Arun District Council
Arun Civic Centre
Maltravers Road
Littlehampton
West Sussex BN17 5LF
Planning & Building Control General Enquiries
Tel: (01903) 737756 Fax: (01903) 730442
Dx: 57406 Littlehampton
Minicom: 01903 732765
e-mail: planning@arun.gov.uk
website: www.arun.gov.uk/planning

Application No: P/161/21/HH
Site Address: 21 Pyrford Close Pagham PO21 3NL
Description of works: Erection of single storey rear extension, front porch, detached garage to side, shed in rear, conversion of loft to habitable use and alterations to fenestration/openings following the demolition of existing rear conservatories.

Thank you for your internet representation made on 3rd December 2021 which has been recorded as an objection with the comments as follows:

W Elevation proposed
1 : 100

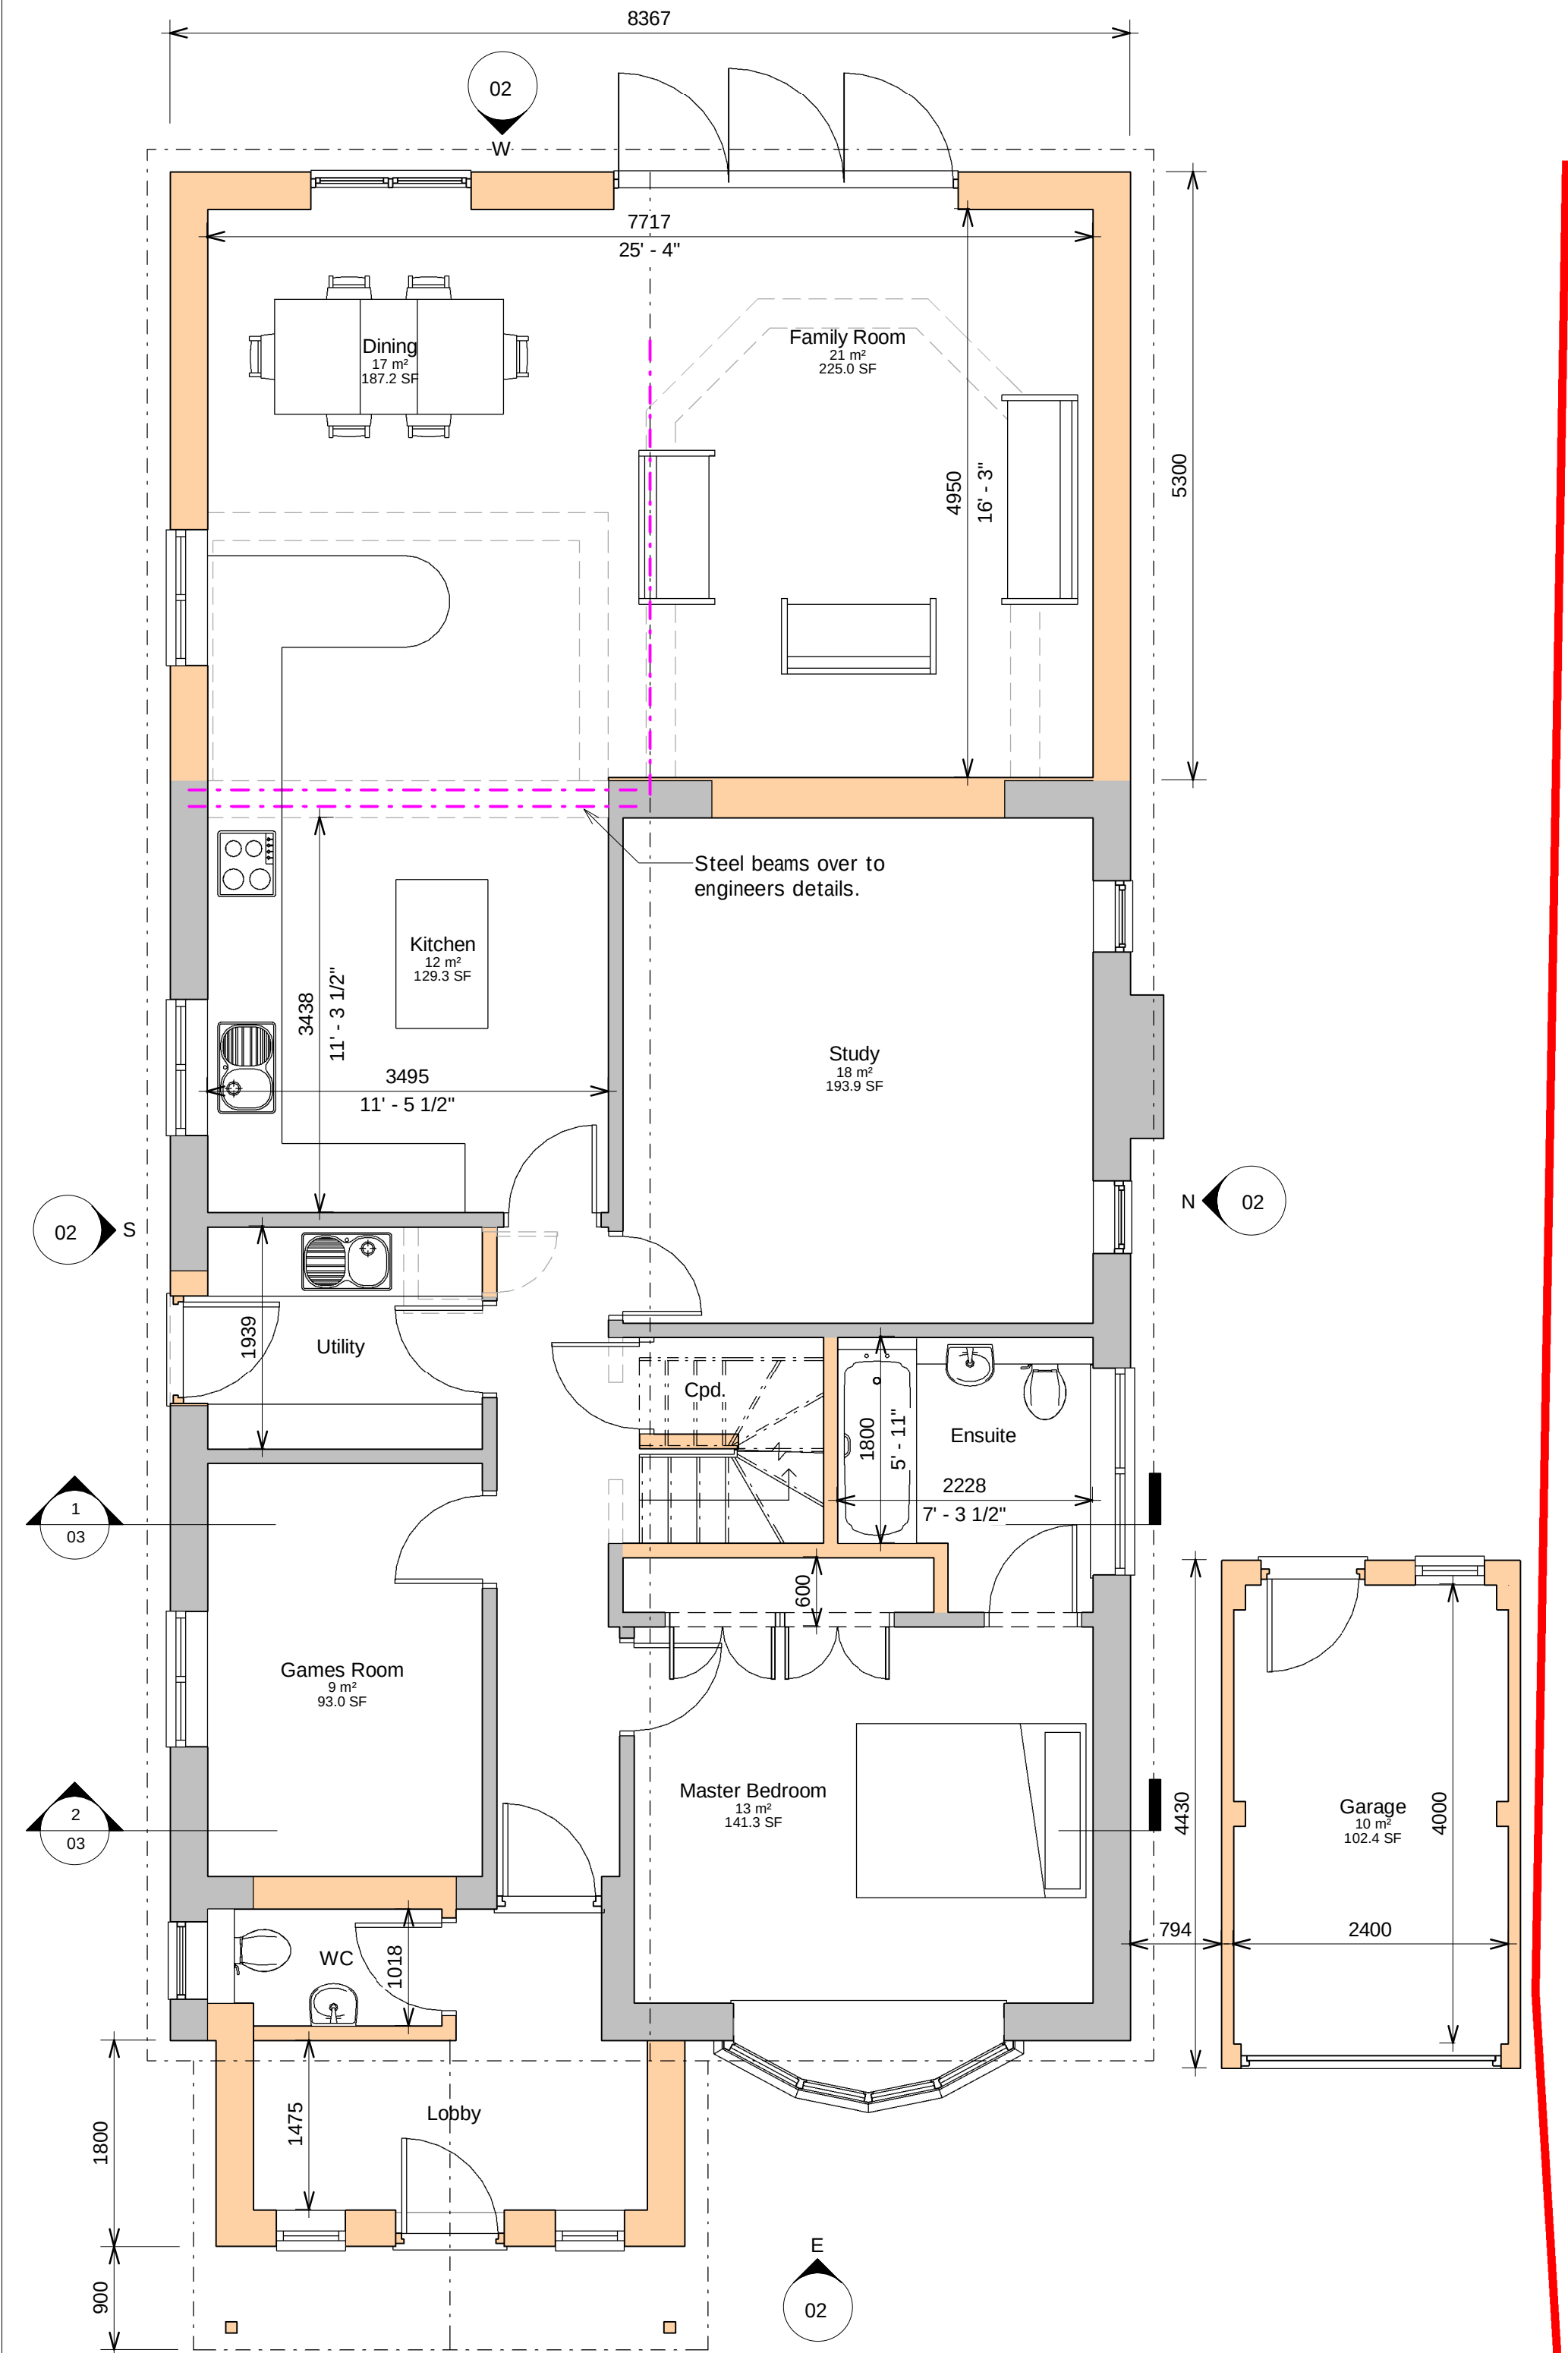
Our concern is windows in the loft conversion , and which
Direction they will face as we do not want to be overlooked
Into our garden and conservatory as our back gardens face
Each other and are extremely close.
We request a copy of the plans asap before we can make
Our final decision
